# CITY OF ALBUQUERQUE

**Re: Shops @ the 24s  
32424 Louisiana Blvd NE  
Grading and Drainage Plan  
Engineer's Stamp dated: 7/23/2018 (H19D001)**

**GRADING & DRAINAGE PLAN**

#### GRADING & DRAINAGE PLAN

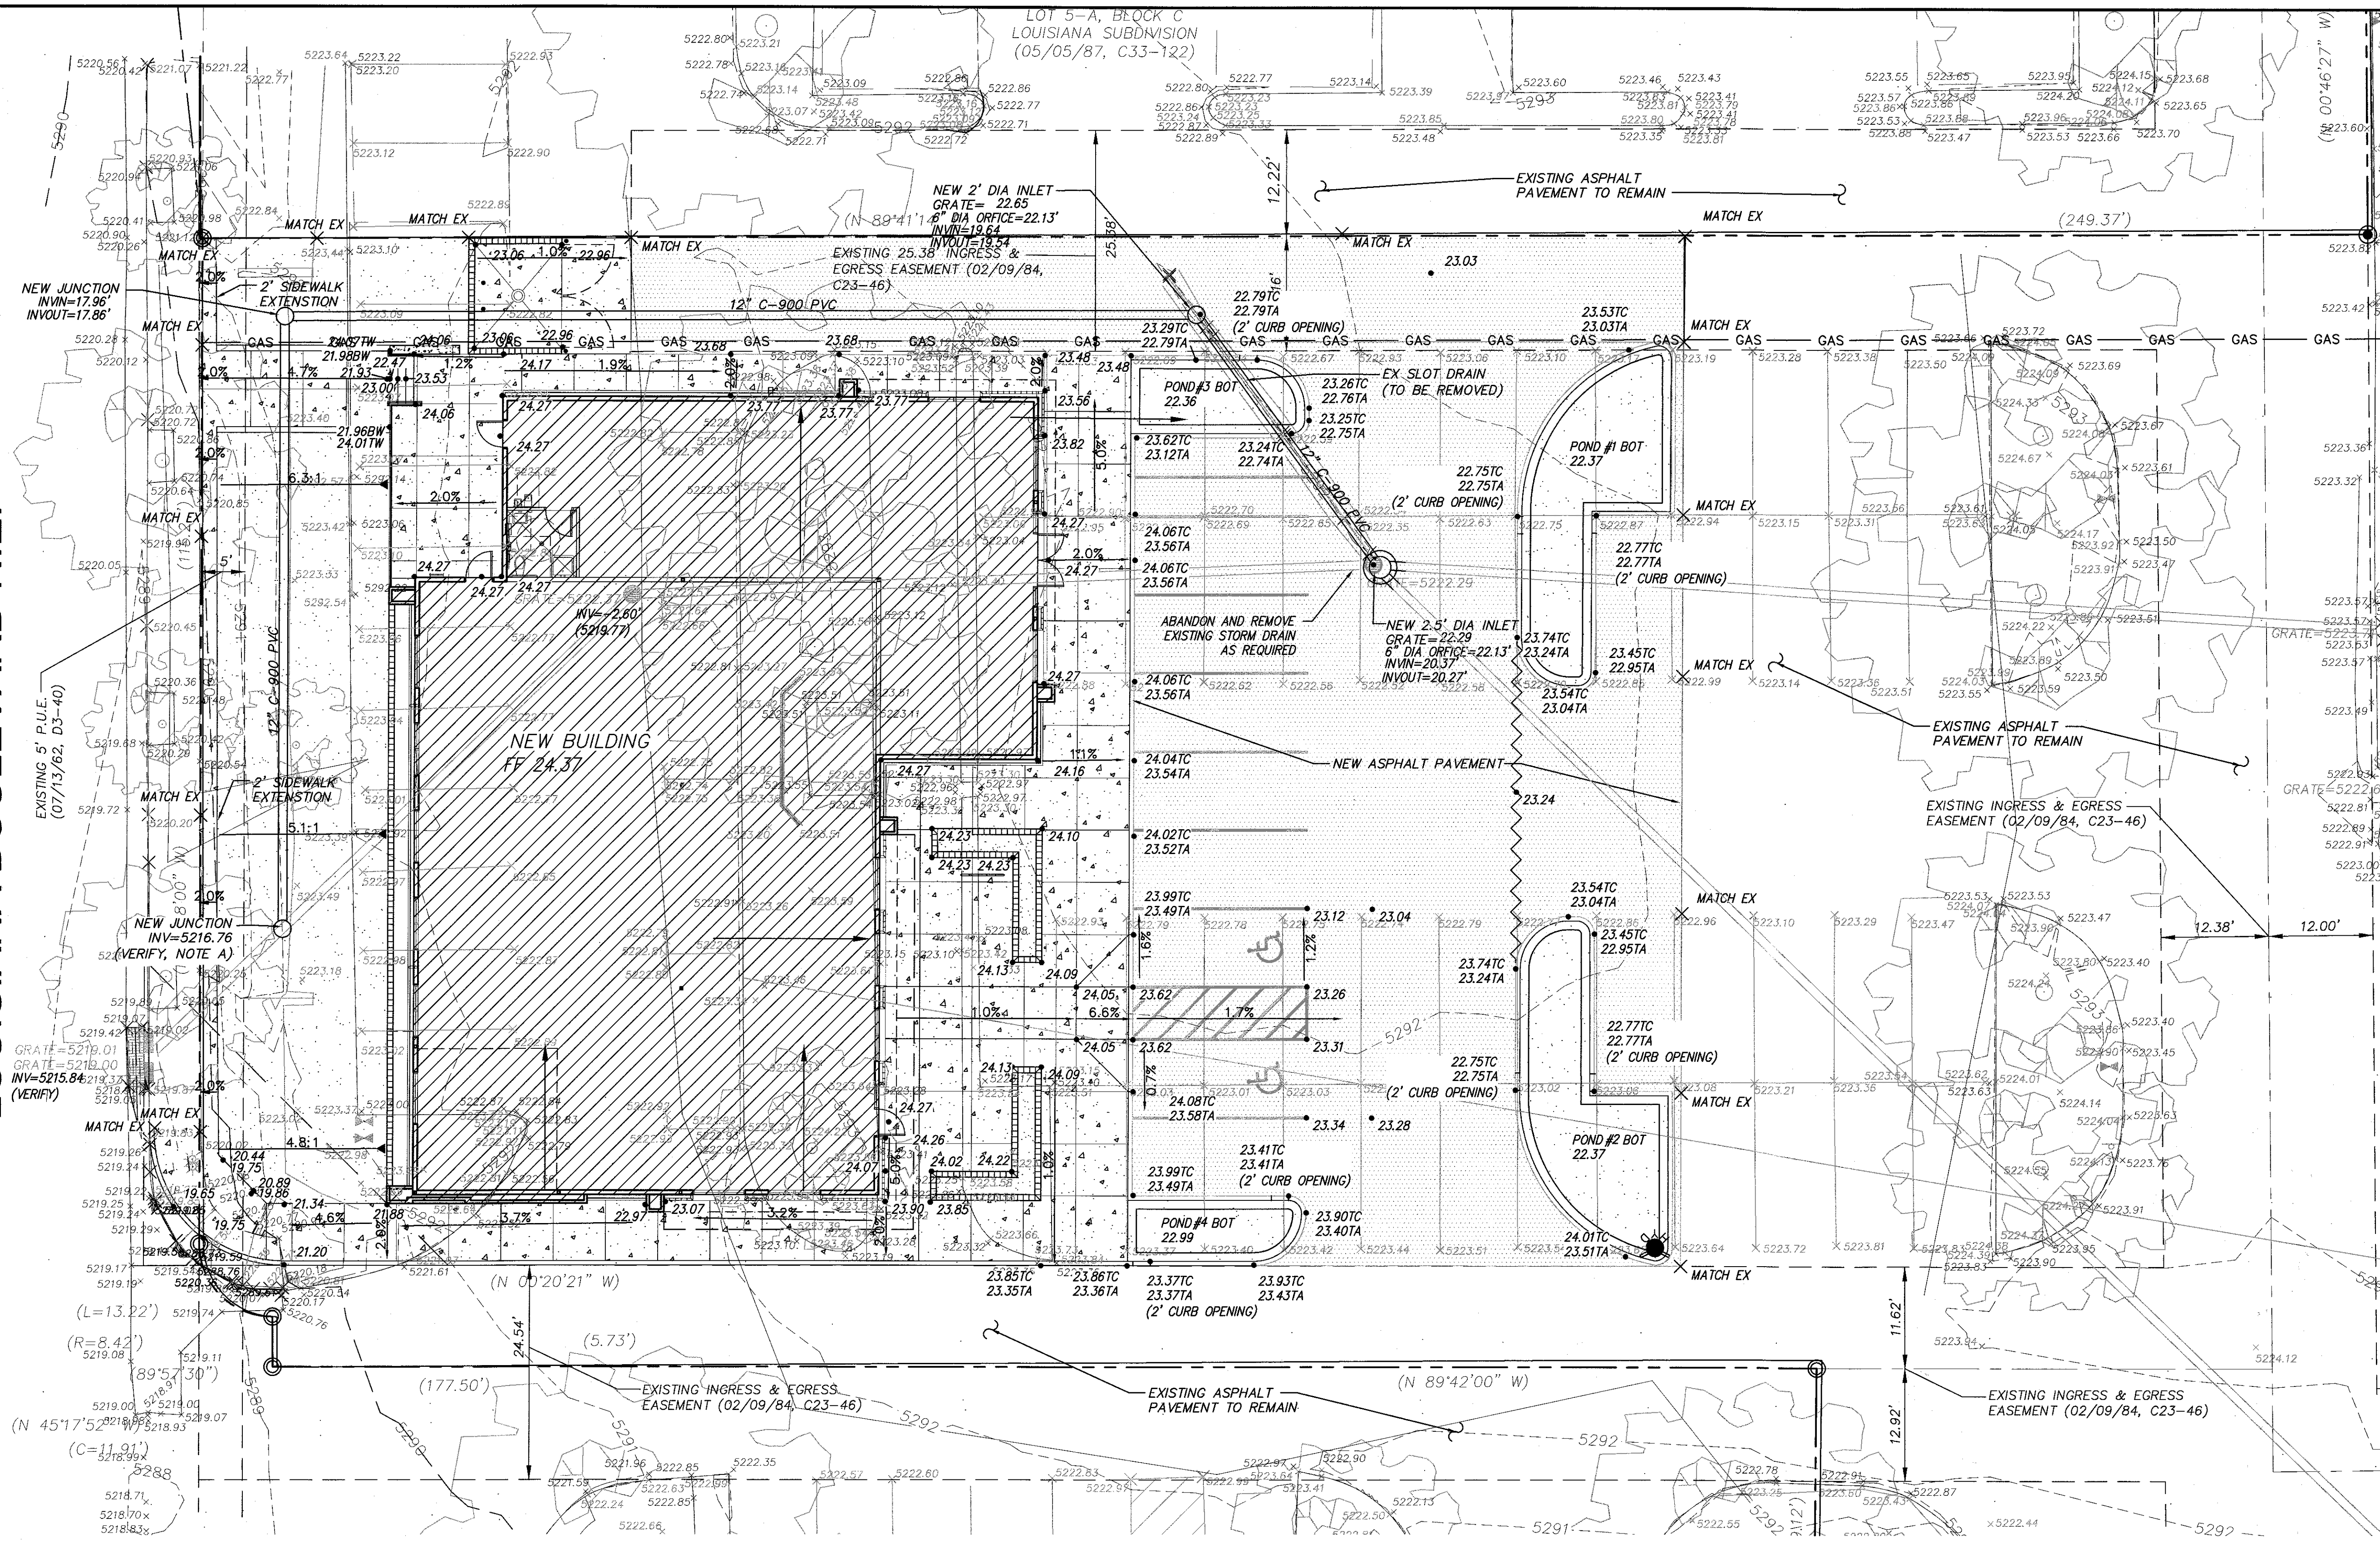
4. Drainage Covenants are required for the detention/retention ponds and private storm drains on this lot.
5. The grading plan is not legible. The proposed pavement hatching obscures existing topography, storm drains, and drainage basin boundaries.

6. Both detention and first flush retention are required. The capacity of the existing storm drain in Louisiana Blvd has been exceeded so the allowable 100-year discharge is 0.1 cfs/acre. The outlet structures on the existing parking lot ponds must be repaired and/or replaced as part of this permit. Include details and construction notes.

7. More detail is needed for all of the ponds including grading details, typical sections, volume calculations, and hydraulic structure details with calculations.
